File No: R/2014/35/B
Our Ref: 2015/155151
Your Ref: SSD 14_6724

RE: Mixed Use Student Accommodation Development at 60-78 Regent Street, Redfern, SSD 14_6724

Reconciliation of Issues

LANEWAY FAÇADE

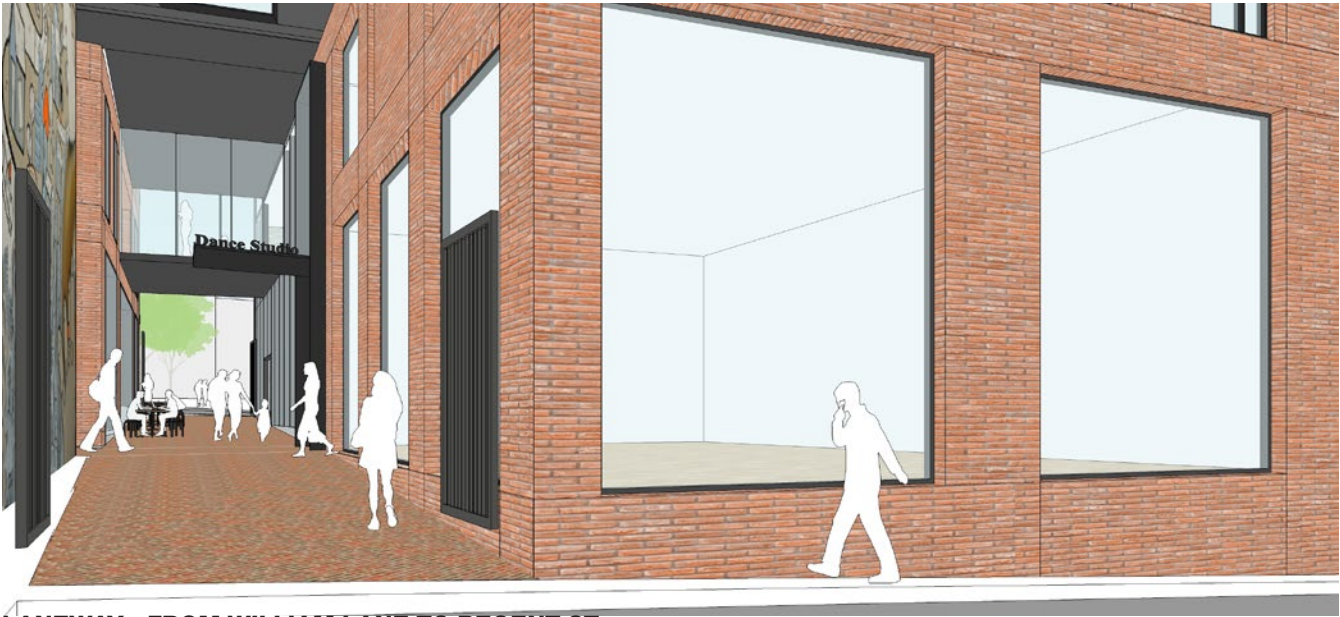
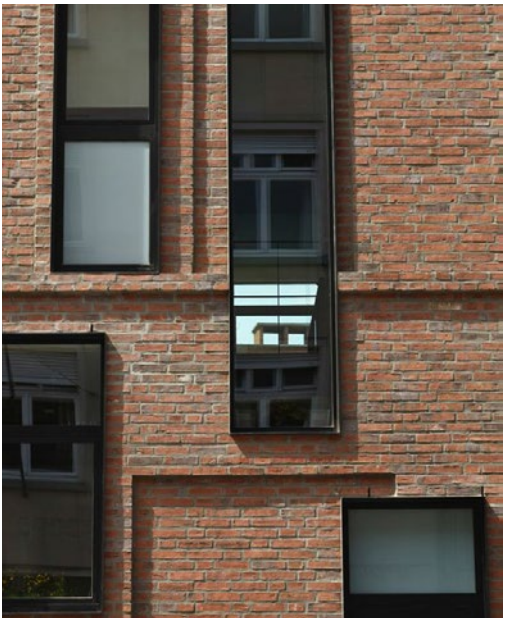
<p>Active uses are encouraged along the laneway to promote pedestrian use. Lighting appropriate to the scale of the space as well as signage should be designed to allow easy identification by users. Detailed design of the laneway will need to consider design elements which clearly delineate between public and private spaces especially in the loading dock area.</p>	<p>This small parcel of land is not in public ownership, but is in fact owned by a deceased estate from the mid-1850s. Iglu has not been able to obtain land owner's consent from the deceased estate for the use of this laneway, and as such it is proposed to remove this parcel of land from the current SSDA.</p> <p>As a result, pedestrian access will no longer be provided via the site through to Redfern Street. All proposed retail tenancies will address Regent Street, with a corridor of land provided within the site for rear-servicing and emergency egress from these tenancies. This site boundary will be secured with a fixed fence. The ground floor tenancies have been designed to accommodate the adaption for active uses to the rear (western) property boundary should ownership of and access over this land be resolved in the future.</p>	<p>Partial</p>	<p>It is understood that Iglu is in the process of acquiring the subject portion of land. The City strongly supports the acquisition of land by Iglu and retention of the original design in order to activate the laneway. To this end the City has confirmed in writing it has no desire to take ownership of the subject land.</p> <p>Should the land acquisition be successful, our comments relating to provision of adequate lighting and signage can be dealt with by way of conditions of consent.</p> <p>The comments raised are still applicable to the treatment of William Lane and the loading dock area and appropriate conditions should be included to address these requirements.</p>

<p>The application requires additional detail regarding ownership and operation, particularly how the closure from midnight to 6am will work, as well as the type of security gate to be installed and access arrangements after hours. Emergency egress during closure should also be considered, particularly with regard to the fire stairs.</p>	<p>Access to the internal laneway will continue to be open to the public operational hours (6am to midnight) to provide access to the dance studio, Iglu lobby and retail tenancies. The Operations Plan states that the on-site manager will be responsible for ensuring that gates are opened and closed at 6am and midnight respectively, and this area will be subject to 24-hour, monitored CCTV surveillance.</p> <p>Emergency egress from the laneway will continue to be provided in accordance with the relevant fire</p>	<p>Yes</p>	<p>N/A</p>

and safety standards. The gates to Regent Street will provide unrestricted outward opening, and emergency egress will also be provided to William Lane via the dance studio lobby and to Redfern Street via a gate in the new fence to the adjoining deceased estate.		
Heritage and Façade Treatment			
<p>The visual impact of the building and impact on the adjoining heritage conservation area to the north, east and south will largely be similar to that of existing views to the adjacent multi-storey buildings including the residential towers at 7-9 Gibbons Street, 157 Regent Street and the twin towers at 1 Lawson Square.</p> <p>There will however, be a greater visual impact on the setting and appreciation of a small portion of the heritage conservation area located adjacent to the subject site including the western end of Redfern Street and a group of buildings in Cope Street. This impact is compounded by the minimal 3m setback of the tower from the Regent Street boundary, and preservation of essentially only street façades of existing buildings fronting Regent Street. This impact is somewhat mitigated by the quality of the adjacent heritage conservation area streetscape, which presents diminished integrity of some existing early 20th century buildings and two intrusive late 20th century buildings in Cope Street.</p> <p>It would be desirable from a heritage and streetscape position to increase the setback of the tower to 8m from Regent Street, as prescribed by</p>	<p>It is important to note that the existing buildings within the Site are not themselves heritage-listed or within a heritage conservation area. Under the relevant planning controls, these shopfronts may be completely removed and replaced with modern tenancies, as has occurred elsewhere on this block. The design solution, which involves the retention and restoration of these shopfronts, is considered to be a far superior outcome in terms of the overall contribution made to the continued history of the streetscape and the relationship with the adjoining heritage conservation area. It is further noted that the retention in full of these buildings would significantly impact on the functionality of both the ground plane and upper levels of the proposed development, and would significantly impact upon internal functioning and amenity.</p>	Yes	<p>It is acknowledged that the provision of adequate building separation to the adjoining buildings to the west needs to be balanced against the provision of an increased setback to Regent Street. Furthermore, the City agrees that there is benefit in retaining the original building façades. As such, a reduced front setback is considered to be acceptable, on the basis that the original buildings are to be partly retained and conserved.</p>
